Development Facilitation Team (DFT) – Review Comments

Project No: PR-2023-008614

Application For: SD-2023-00097—PRELIMINARY/FINAL PLAT (DHO)

Application For: VA-2023-00124—SIDEWALK WAIVER (DHO)

Sidewalk Exhibit

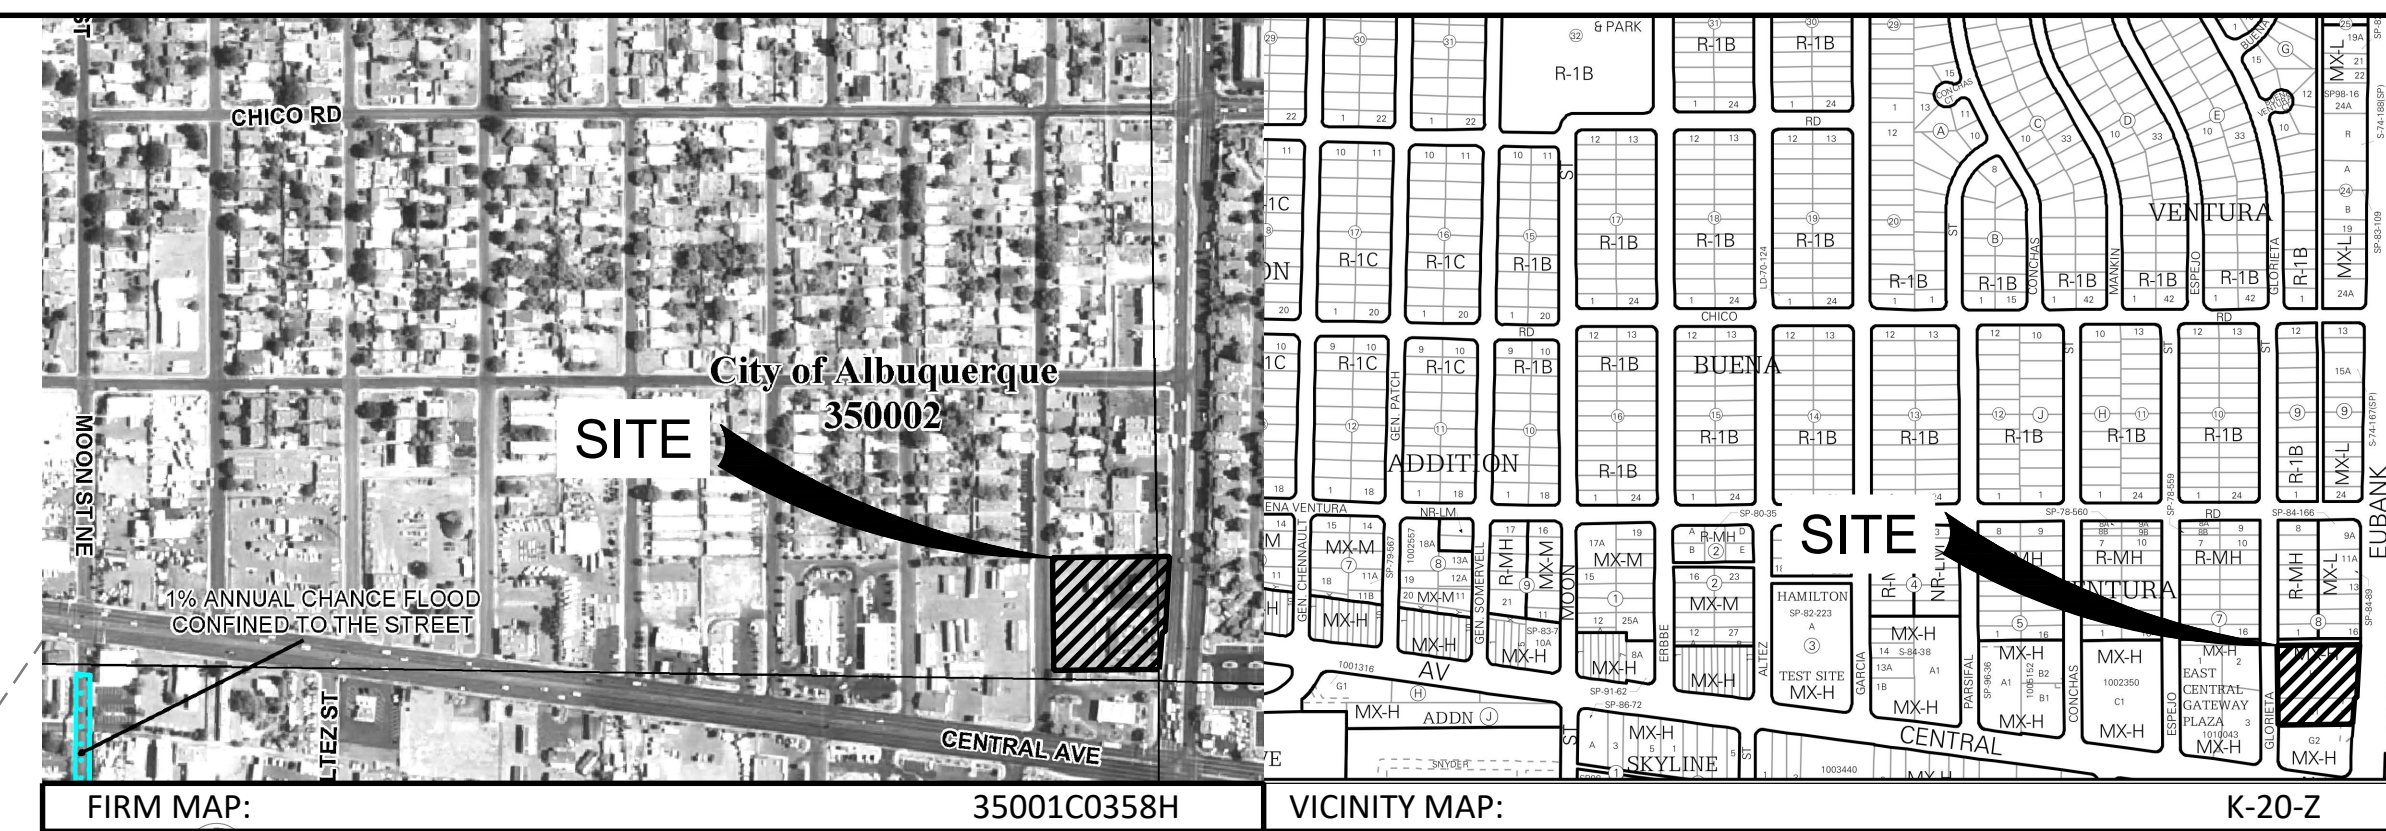
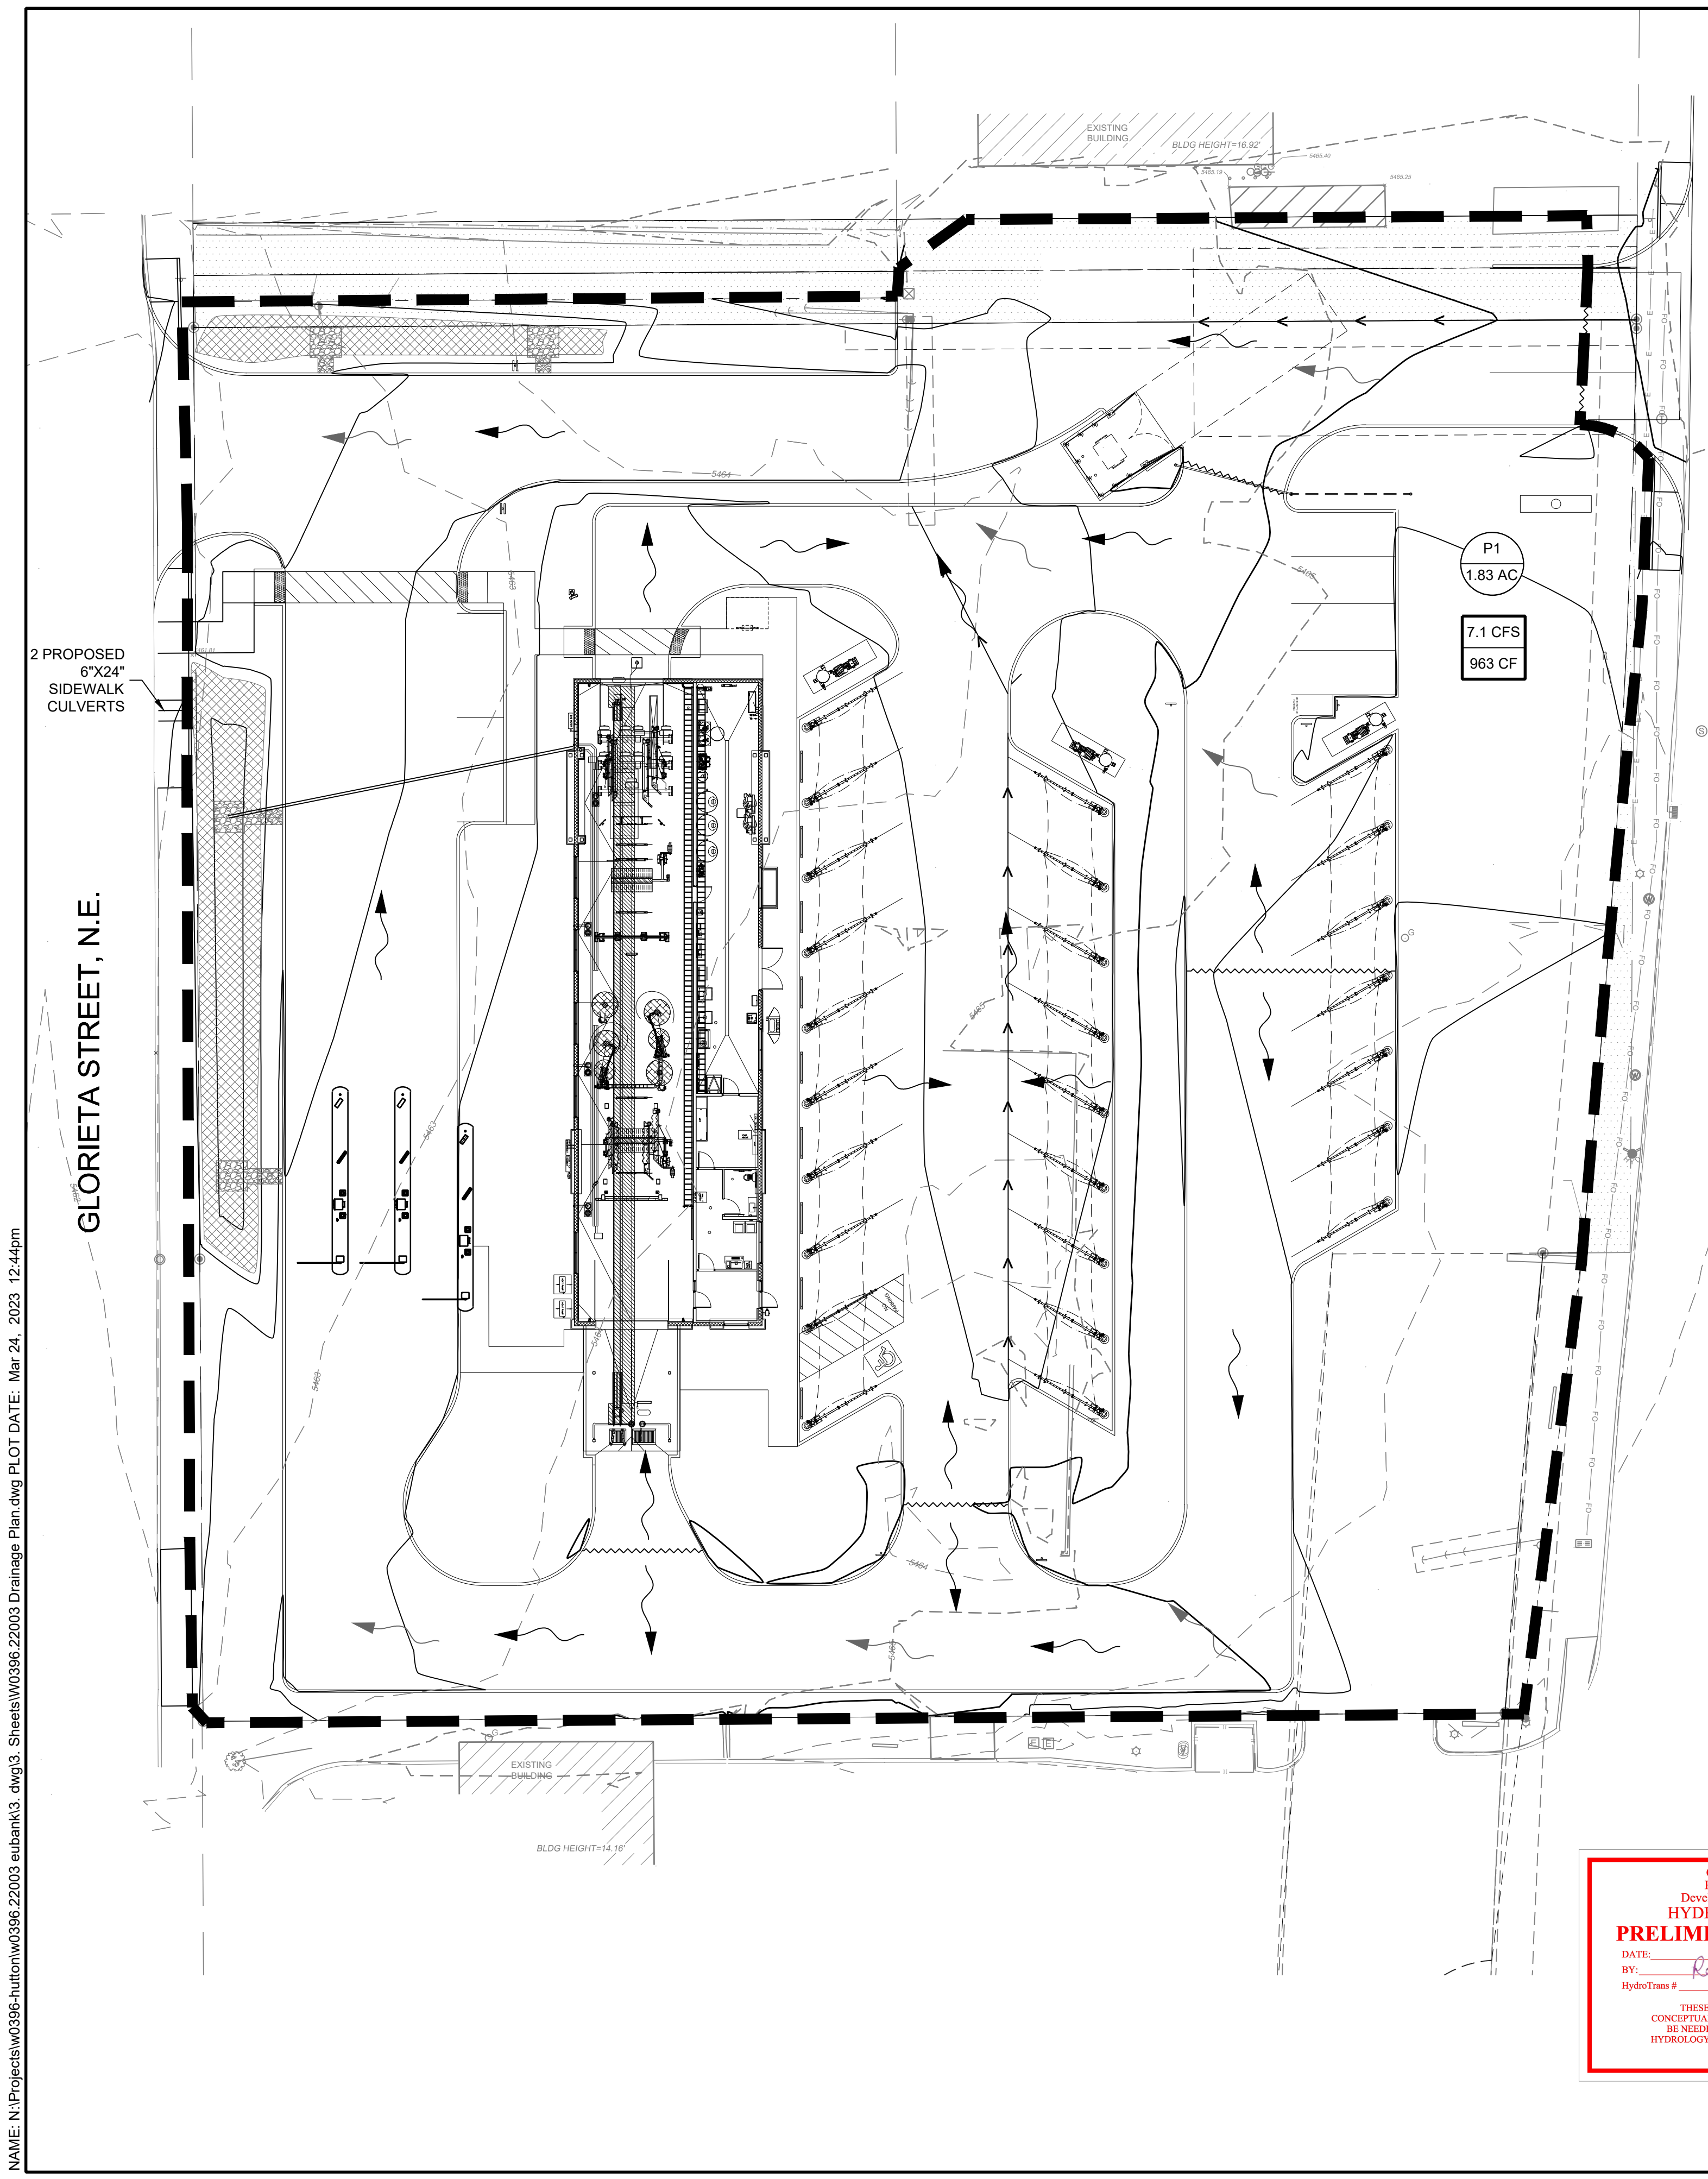
1. The justification to allow sidewalk to remain 5.9' is acceptable and no comments on the plat. No objection.
2. Informational: Future site plans require a Traffic Circulation Layout approval prior to building permit. Please check the landscape plan against clear sight triangle to ensure there will be no obstructions in the triangle.

- The Applicant has applied for a Sidewalk Waiver for the existing 5.9-foot wide sidewalk along Eubank Blvd, which is required to be at least 6-feet in width. The requested Waiver is not materially contrary to the public safety, health, or welfare and will not cause material adverse impacts on surrounding properties, as this sidewalk was constructed long before this request came to pass. There are also existing obstructions on the sidewalk that cannot be easily relocated (light pole and fire hydrant), and this Waiver request will also encourage flexibility in accordance with site planning process and encourage flexibility in accordance with existing site conditions. Therefore, this Waiver request is adequately justified and staff have no objection to the request.

Please verify that the requested sidewalk waiver will not impact future planting. No additional comments.

EXHIBIT 2

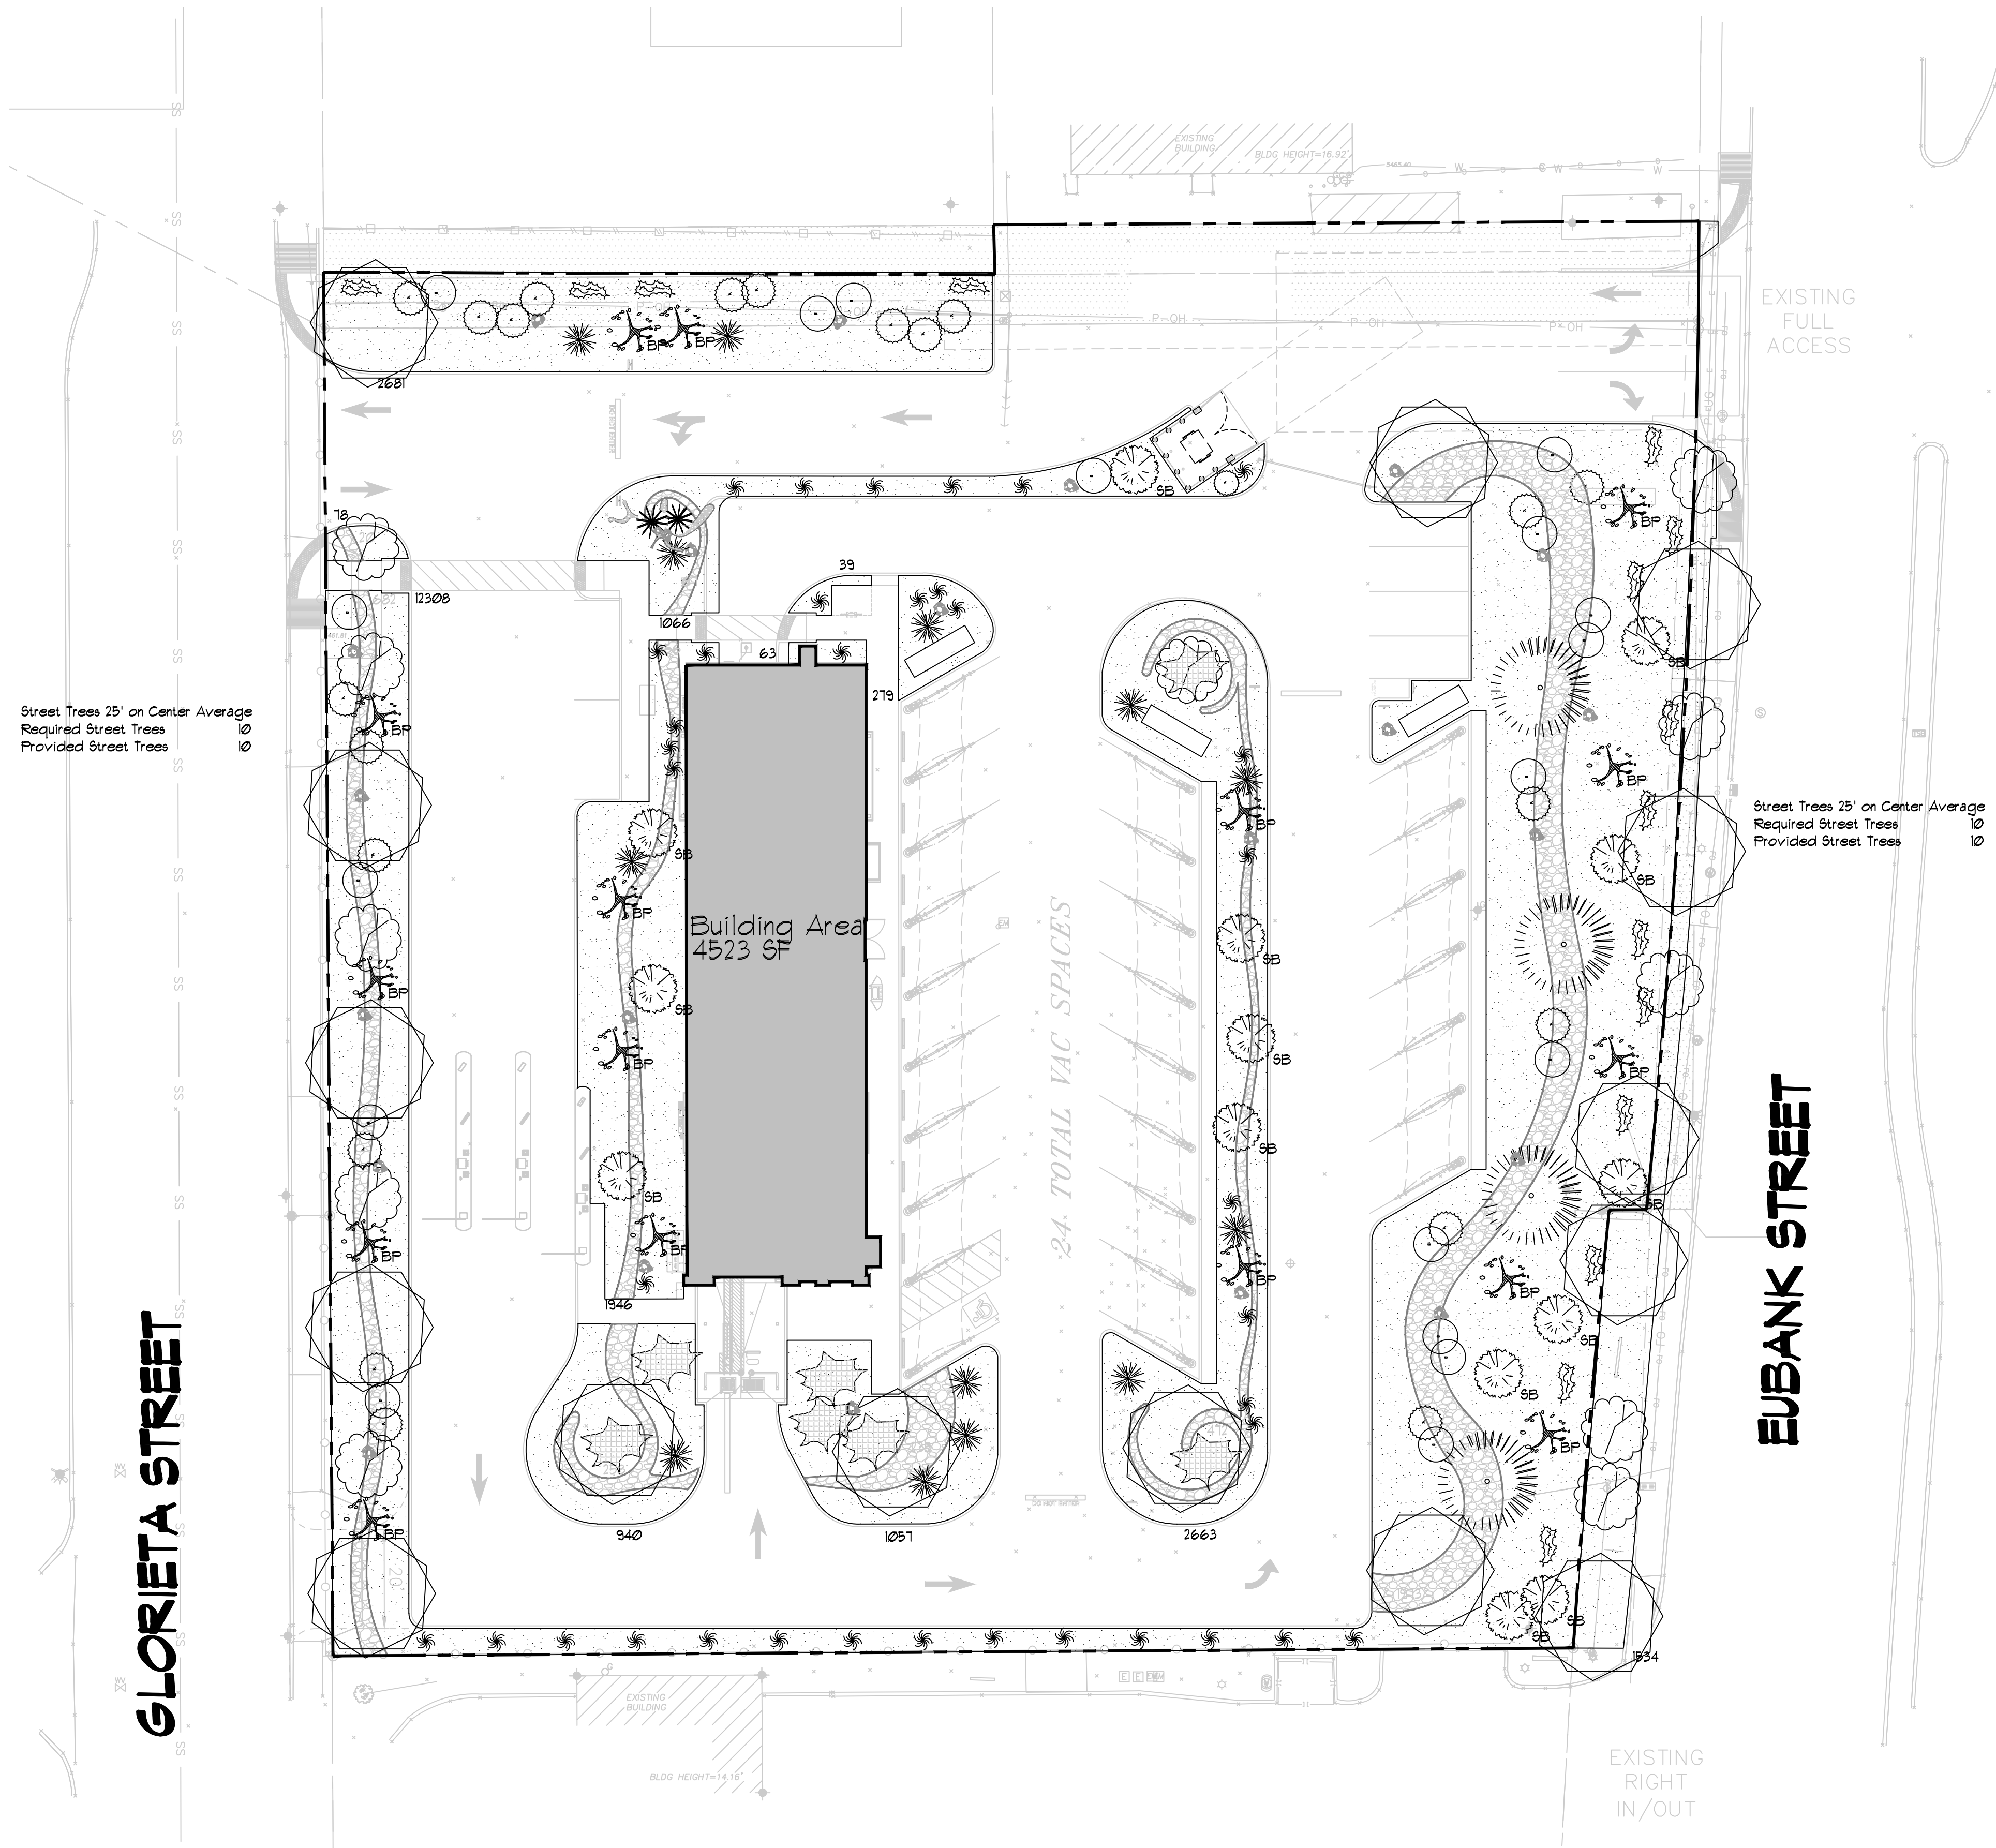
Please note that future development of the site will require Street Trees along Eubank Blvd. Please see IDO Subsections 14-16-5-6(B)(1) for Applicability and 14-16-5-6(D) for Landscaping Requirements.
